City of Albuquerque Stormwater Construction Site Inspection Report

General Information					
ESC File No.	K09E052	Project Name:	98th and Central Warehouse		
NPDES Id. No.	NMIR10065E	Location:	9561 Central Ave NW		
11/19/2024	Owner			Contractor	
Operator	98 and Central Partners LLC				
Contact name & title	Alfredo Barrenechea				
e-mail	alfredo@go-absolute.net				
Contact Phone #	505-246-6006				
COA Inspector	Chancellor English		Start/End Time:	130pm	
Construction Phase:	Grading				
Type of Inspection:	Regular	Storm Event	Post Storm Event >0.25"	311/Complaint	Follow Up
Weather at time of inspection?	Clear		Temperature: ~	50	
Estimated date of last storm 0.25" or greater	11/7/2024

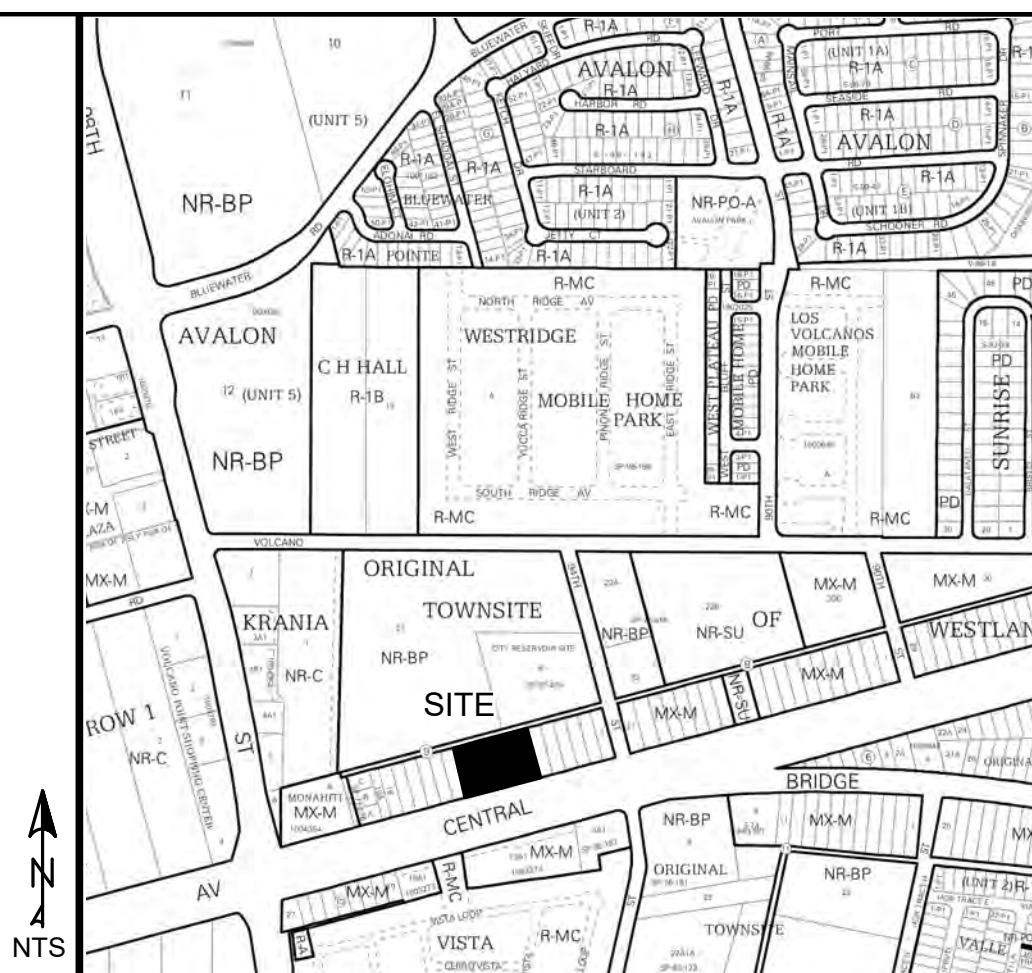
3	BMPs - The perimeter silt fence has some damage and is not preventing sediment discharge, and the construction exit has no track-out measures in place in violation of CGP Parts 2.1.3 and 2.1.4. Required mitigation: Complete installation of stormwater controls by the time each phase of construction activities has begun per CGP 2.1.3. By the time construction activity in any given portion of the site begins, install and make operational any downgradient sediment controls (e.g., buffers, perimeter controls, exit point controls, storm drain inlet protection) that control discharges from the initial site clearing, grading, excavating, and other earth-disturbing activities. Ensure that all stormwater controls are maintained and remain in effective operating condition during permit coverage and are protected from activities that would reduce their effectiveness per CGP Part 2.1.4
